WEST SUSSEX COUNTY COUNCIL CONSULTATION

TO:	Arun District Council FAO: Andrew Wood
FROM:	Highways, WSCC
DATE:	14 th June 2018
LOCATION:	Castlevew Nursery, Old Mead Road, Lyminster, Littlehampton, West Sussex, BN17 7PU
SUBJECT:	LU/131/18/PL Erection of 2 No. new buildings for caravan/motorhome storage & self- storage in place of existing glasshouse & building approved under application LU/47/16/PL. This application is a Departure from the Development Plan.
RECOMMENDATION:	☐ Advice ☐ Objection ☐ Modification ☒ No Objection ☐ More Information ☐ Refusal
S106 CONTRIBUTION TOTAL:	£N/A

Proposed Site Layout

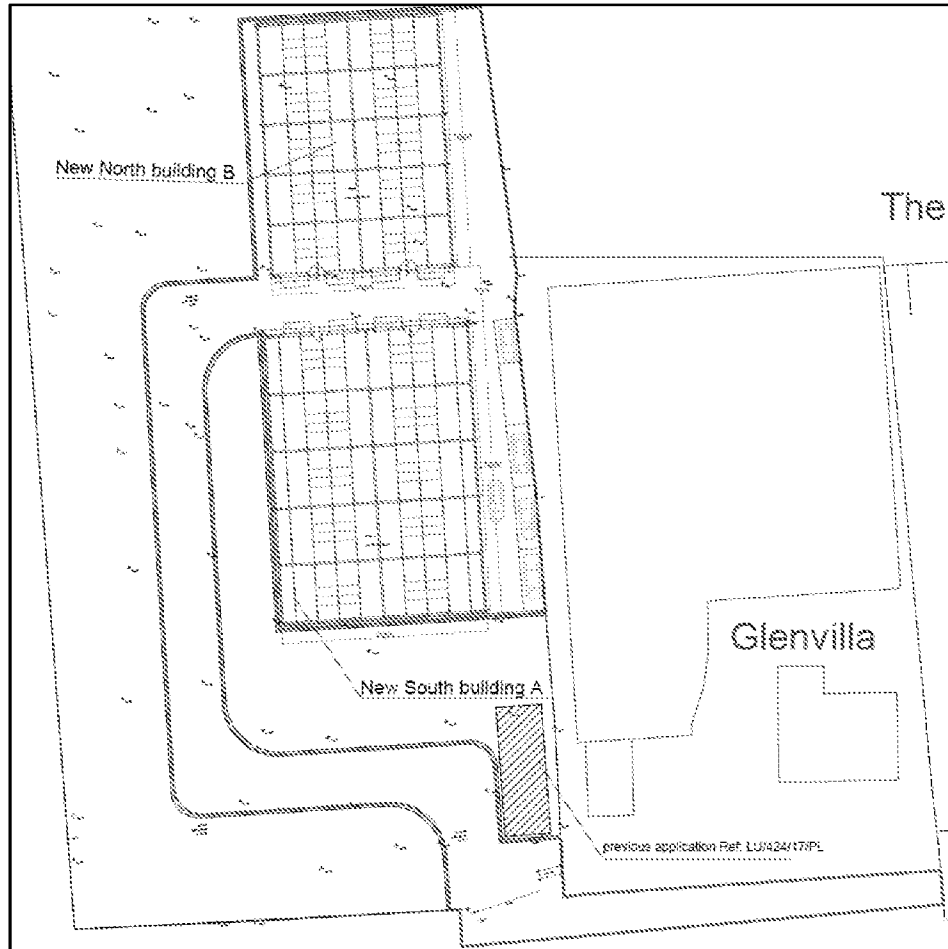
No changes to the existing access routes into and within the site are proposed. From an inspection of the plans the existing access from the culmination of Old Meads Drive into the site does not appear wide enough to allow two cars to pass. The applicant may wish to consider widening this access route. Nevertheless, the LHA do not consider that a reverse manoeuvre on to the *public highway* would result and thus this is more a practicality consideration.

Within the site there are certain points where the access route does not appear wide enough to allow two vehicles to pass. Again considering the nature of the storage facility with larger vehicles (caravans/ motorhomes) the applicant may wish to consider widening access routes to improve manoeuvrability on site. Again this would not cause a highway safety concern.

I note that 5 x parallel car parking bays have been provided to the east of building A for clients. Access to these would not allow for two cars to pass but the LHA consider that the nature of the storage facility would mean that a capacity issue within the site would not result. Furthermore, there are places where a car can wait for another to pass within the site and a highway safety concern would not be anticipated as a result of the internal layout design.
